**Consultation Response from KC,
Highways Development Management**

2021/94542 Poplar Farm, Bristfield Road, Bristfield, Dewsbury, WF12 0PA

Alterations to integral garage to extend living accommodation and alterations to parking facilities

Date Responded: 26/01/2022

Drawing Title
Proposed Plans

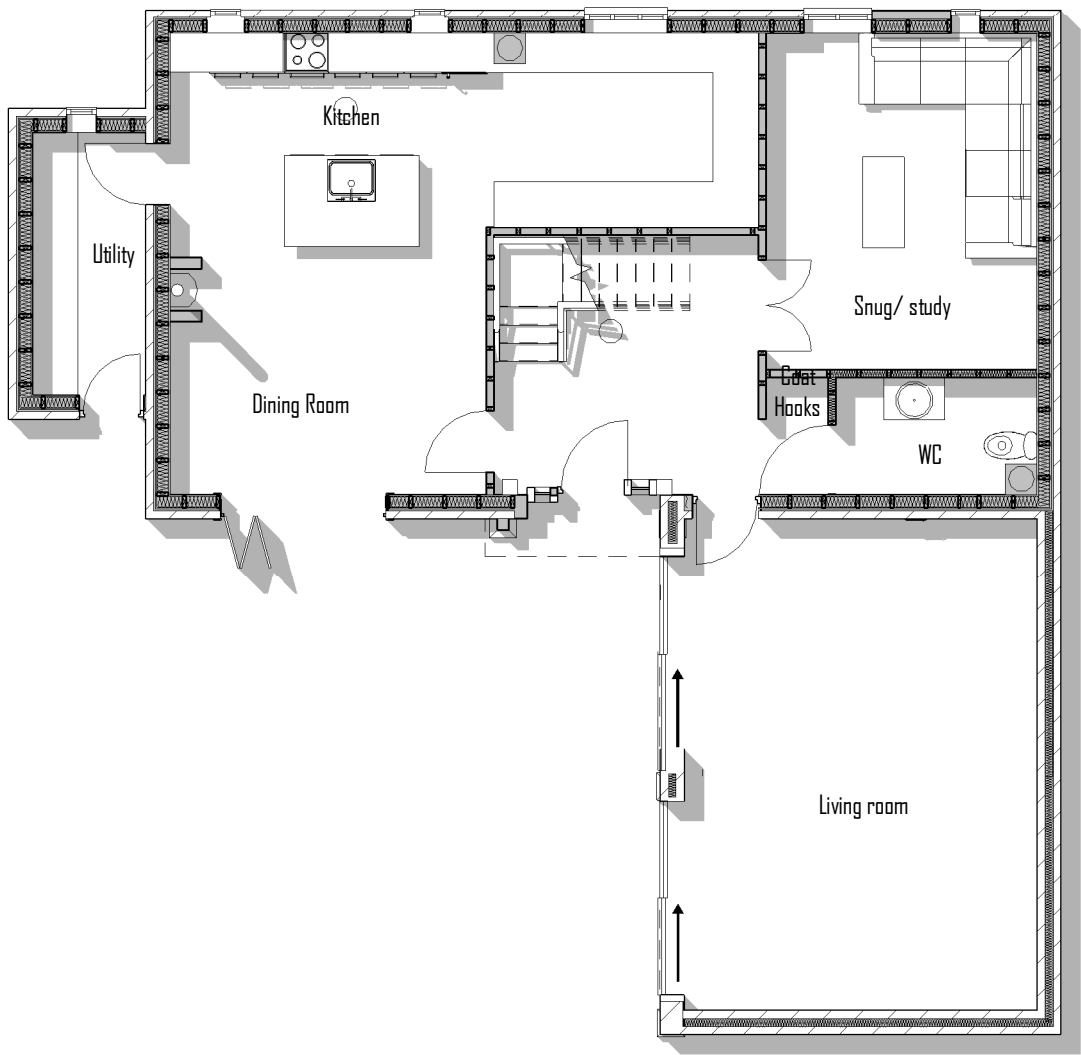
This application amends the proposals for plot 3. The floor plan shows the proposed under-croft/garage car parking to plot 3 removed and replaced with living space.

Landscaping Plan

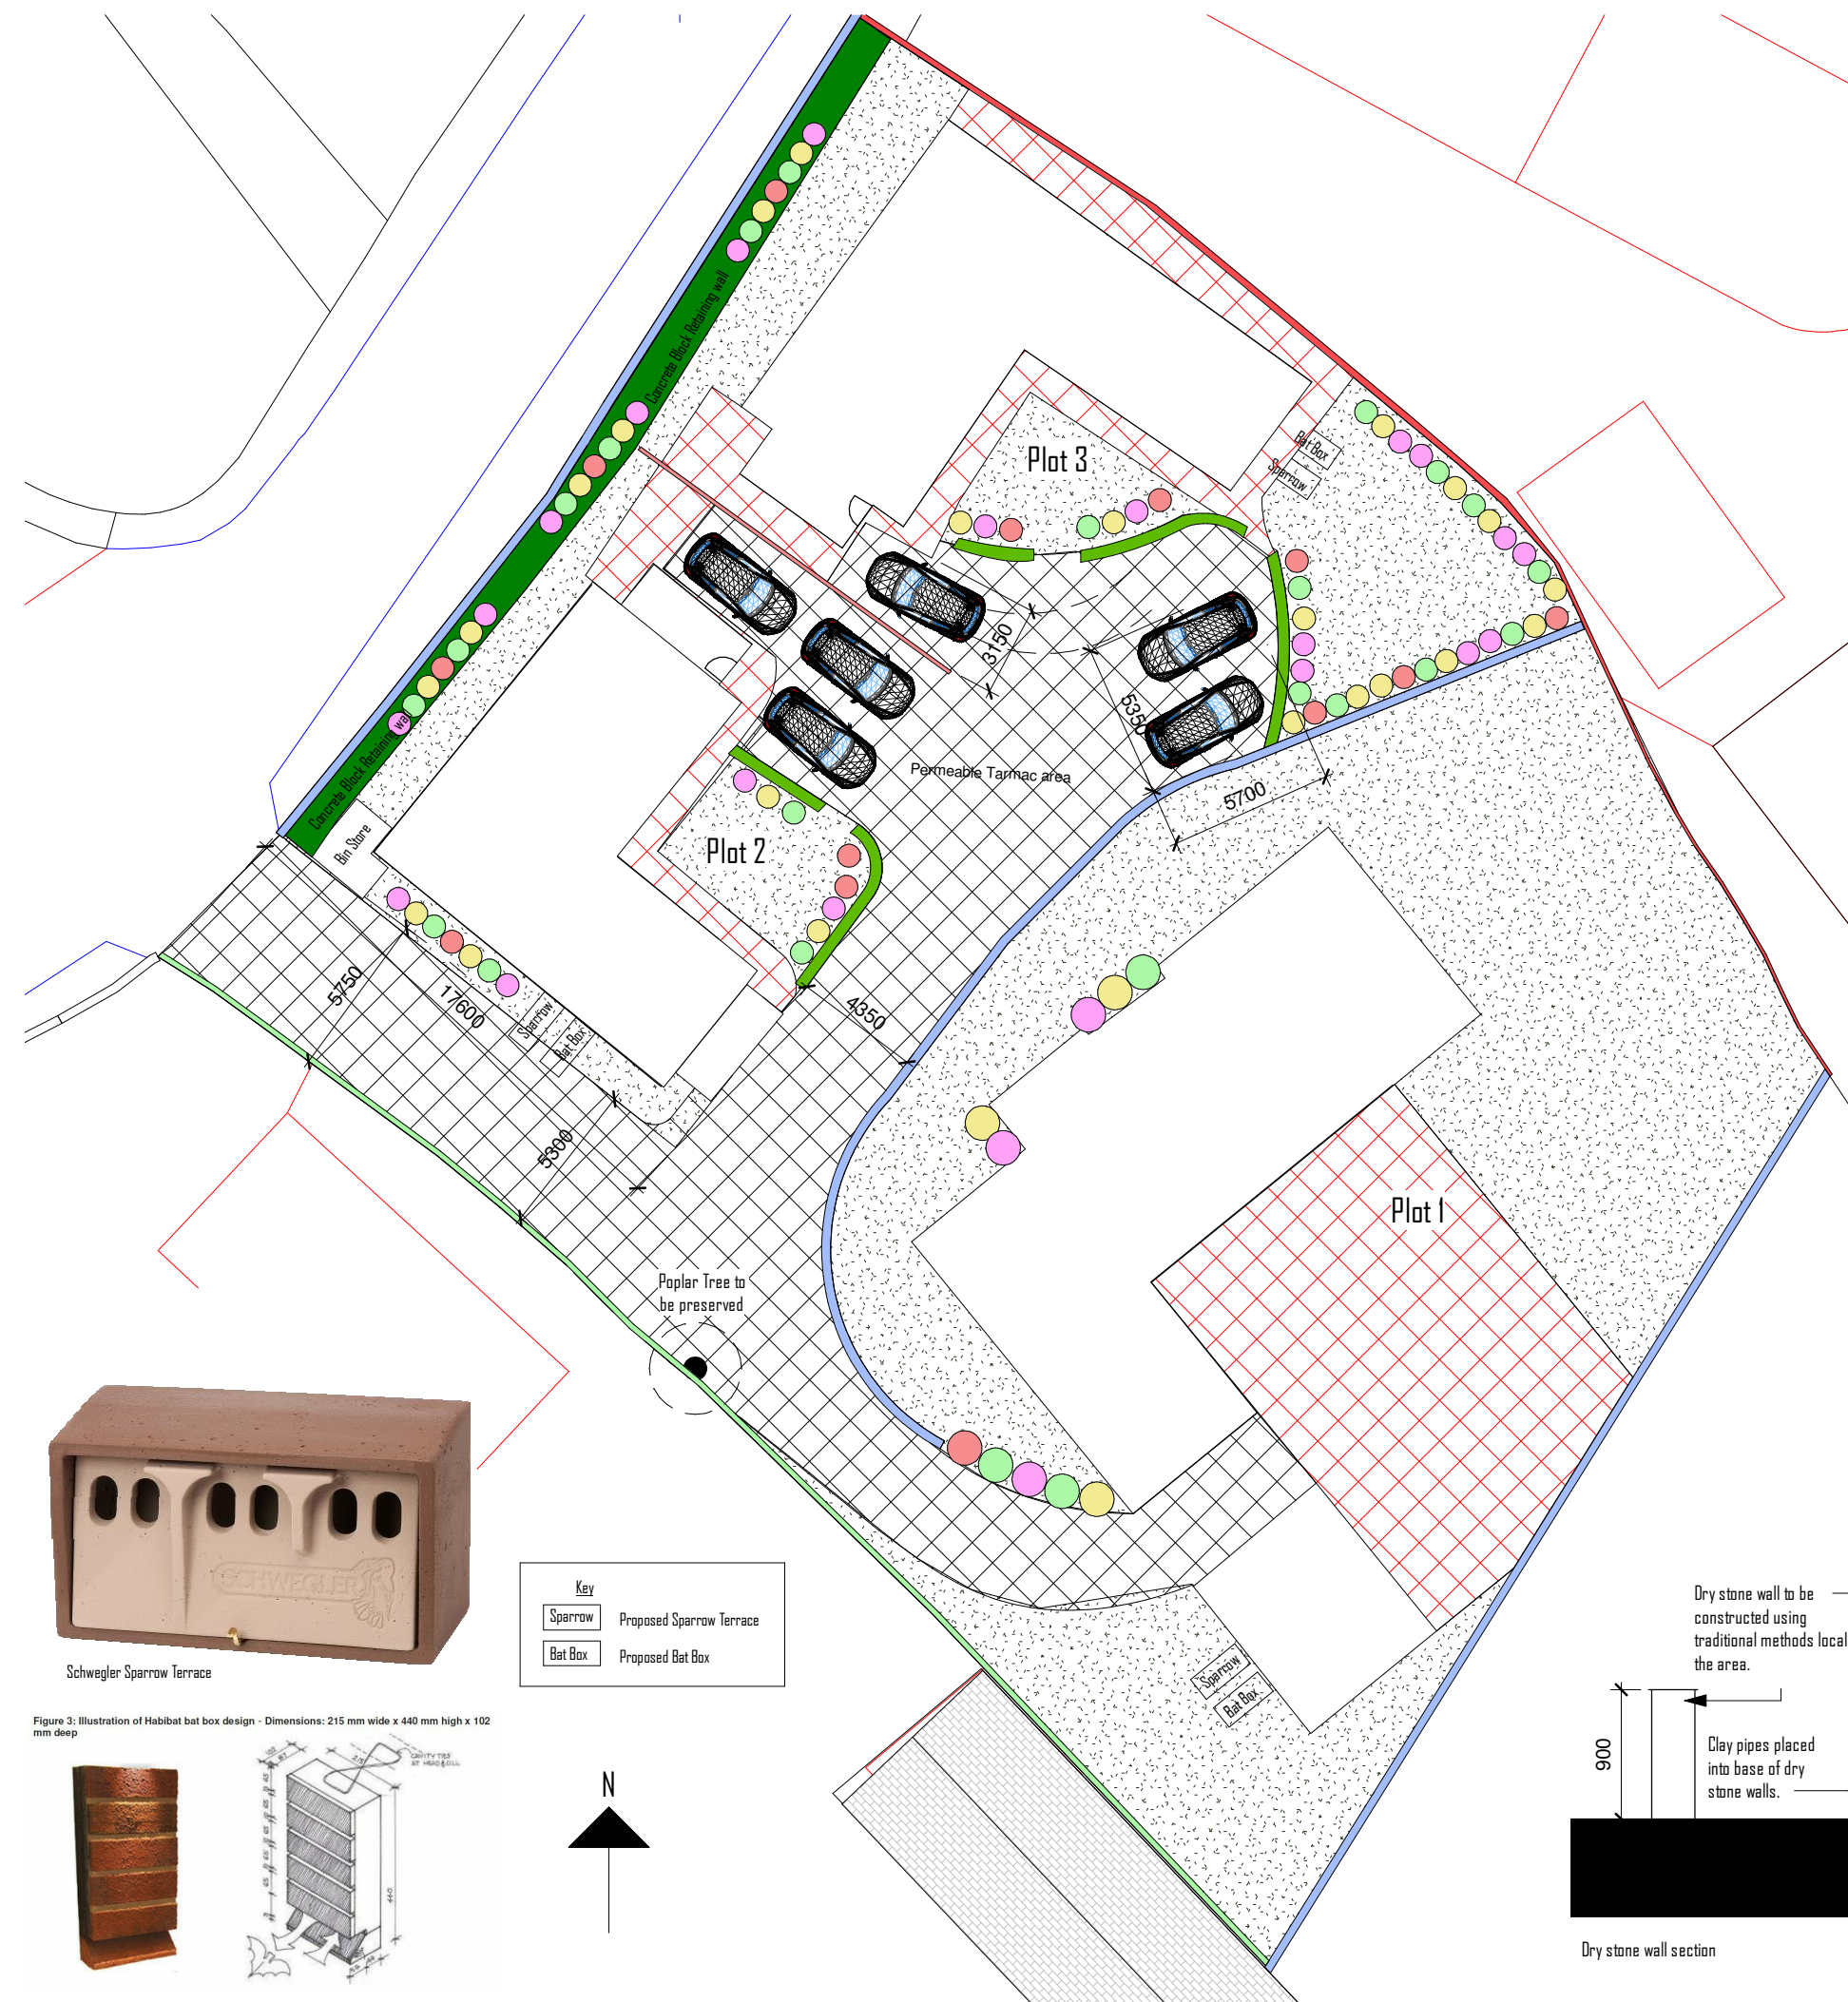
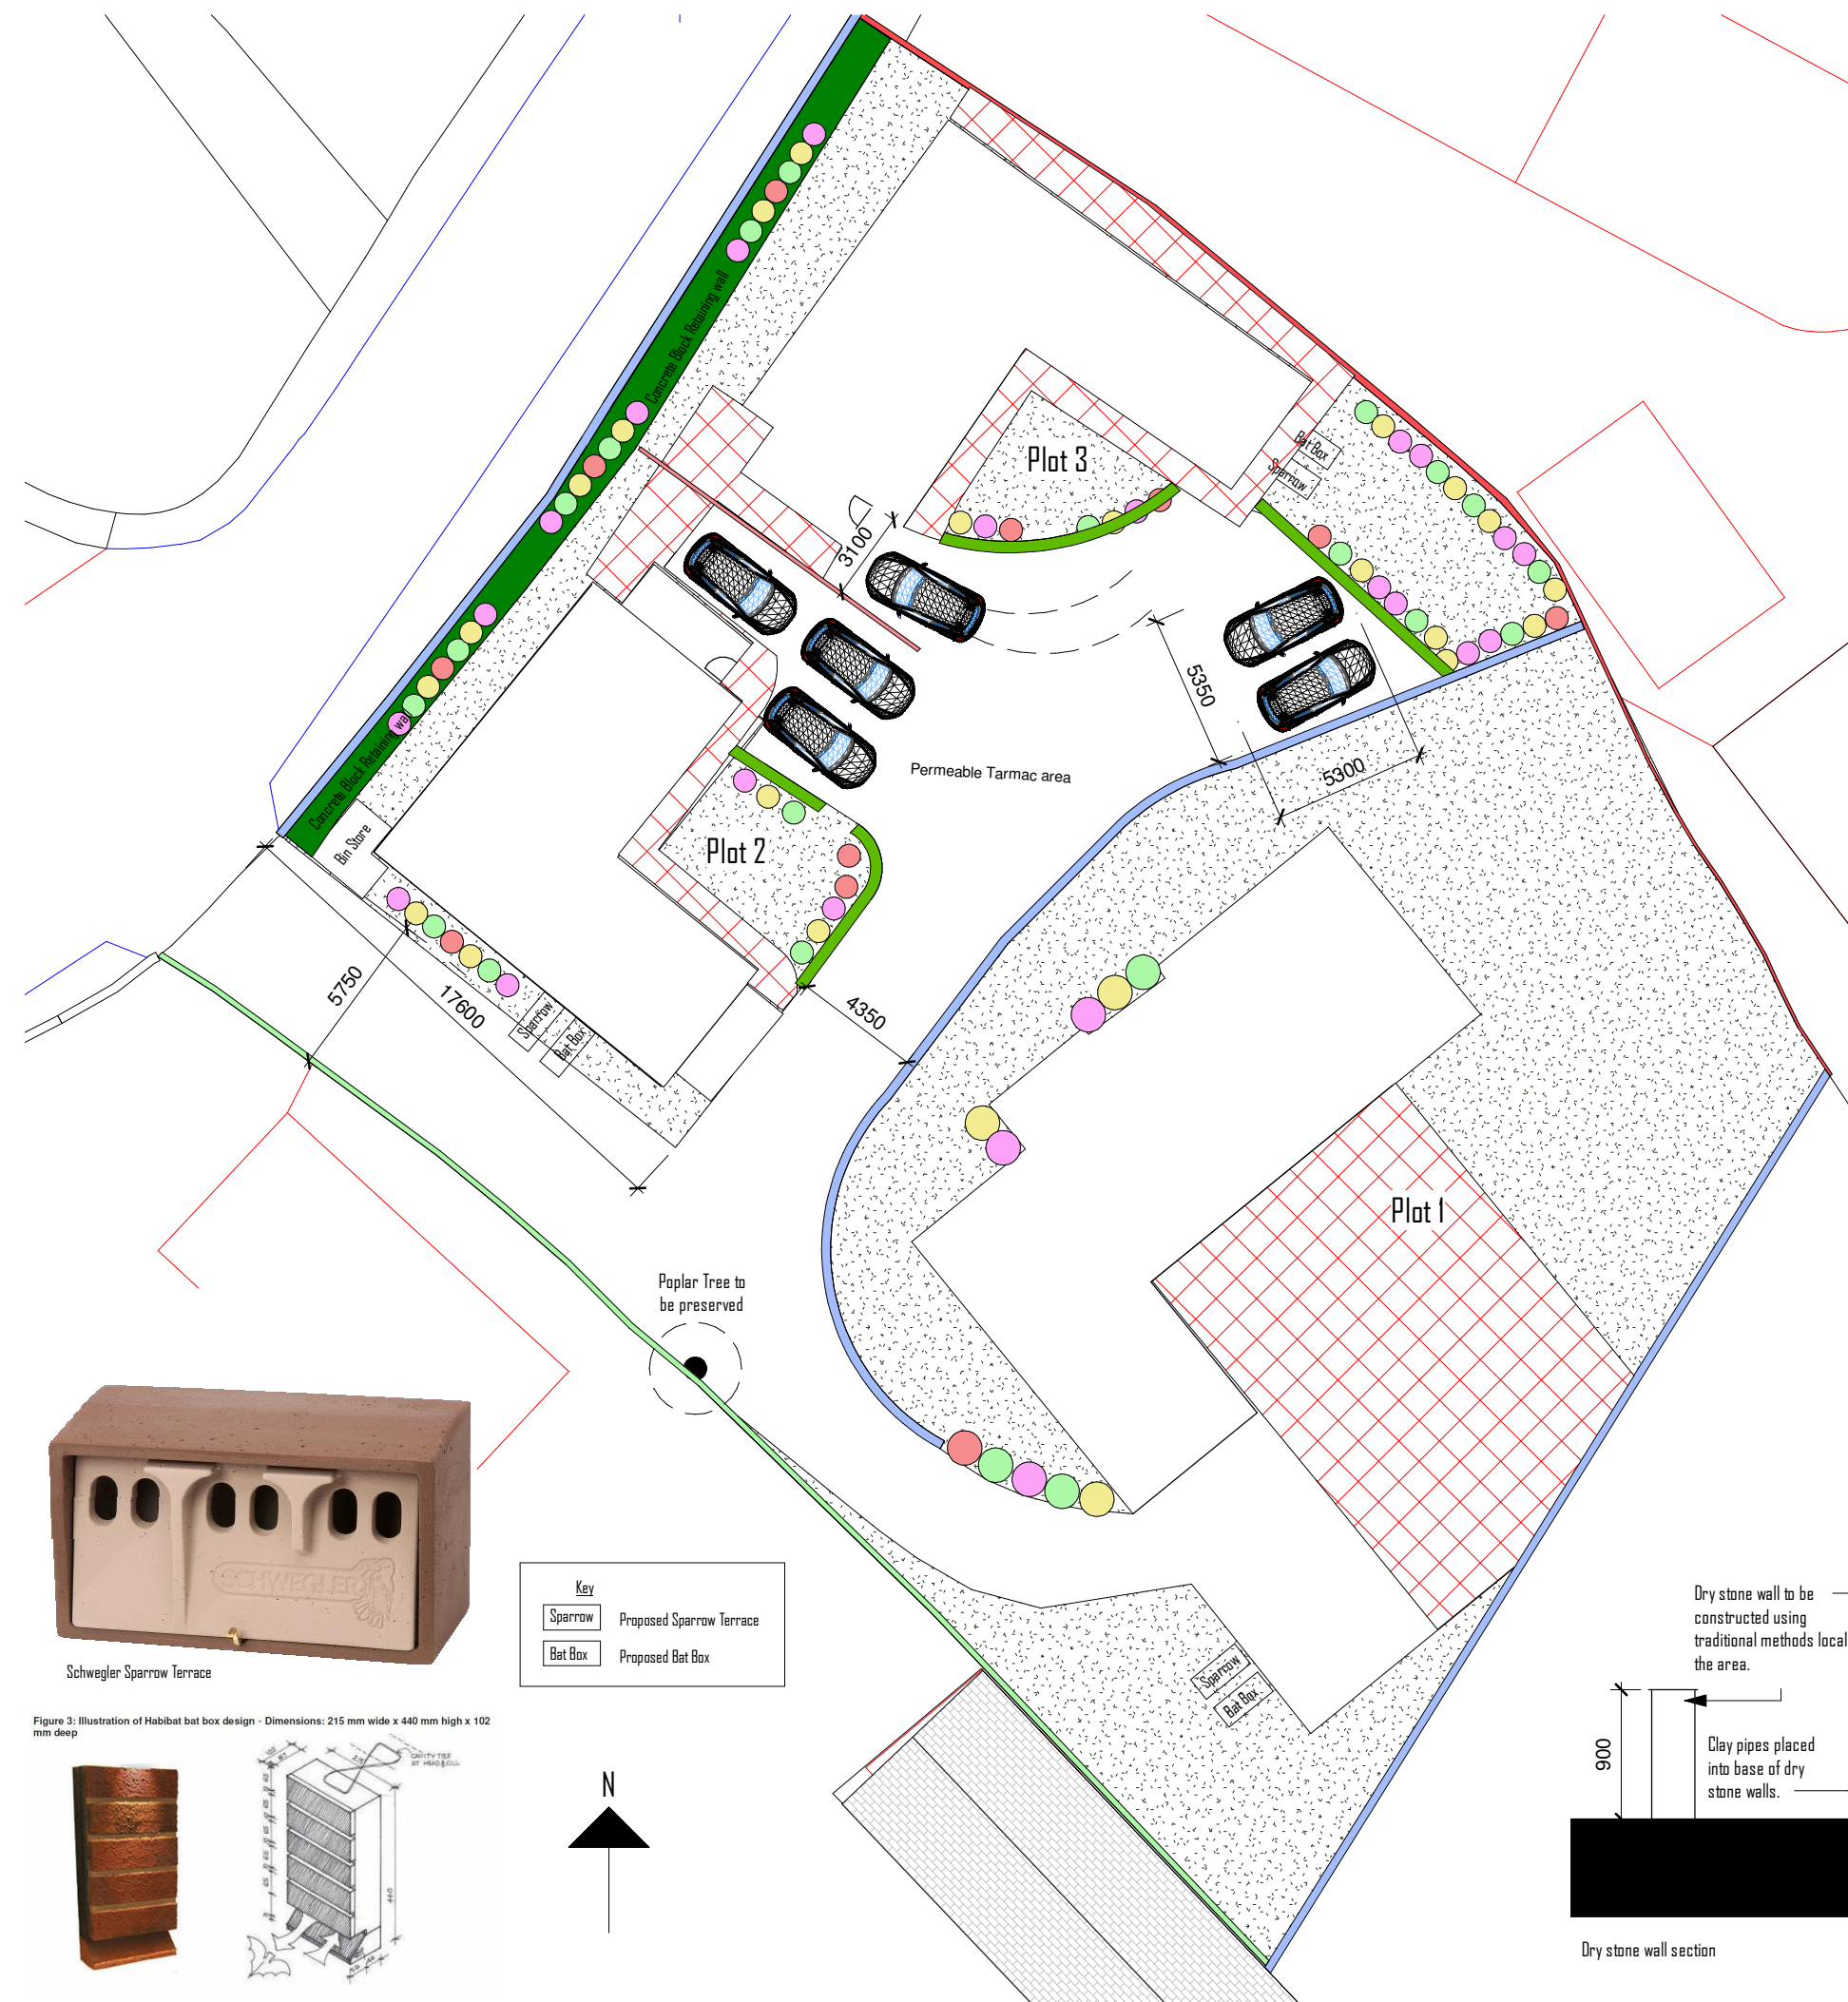
The landscaping plan 2050-14-F provided shows the driveway to the front of the under-croft/garage car parking to plot 3 removed and replaced with landscaping. This also appears to effect plot 2 with the access to the garage shown on the removed and replaced by landscaping. This plan shows the proposed replacement parking for plots 2 and 3 (7 spaces) within what appears to be a shared driveway/turning space.

The parking layout shown is cramped with five spaces between plots 2 and 3 and two spaces opposite adjacent to the boundary with plot 1. The 2 parking spaces adjacent to the boundary with plot 1 obstruct access to the 5 spaces shown between plots 2 and 3.

Highways Development Management consider that this proposal provides only 4 independently assessable parking spaces between plots 2 and 3. The other spaces shown are not considered acceptable given that two obstruct access and a third is located on paving and not the shared tarmac driveway.

The recommended standard for a 4+ bedroom dwellings is three off-street parking spaces.

This proposal has shown is considered un-acceptable. These proposals should be amended to show 3 independently assessable parking spaces to both plots 2 and 3.
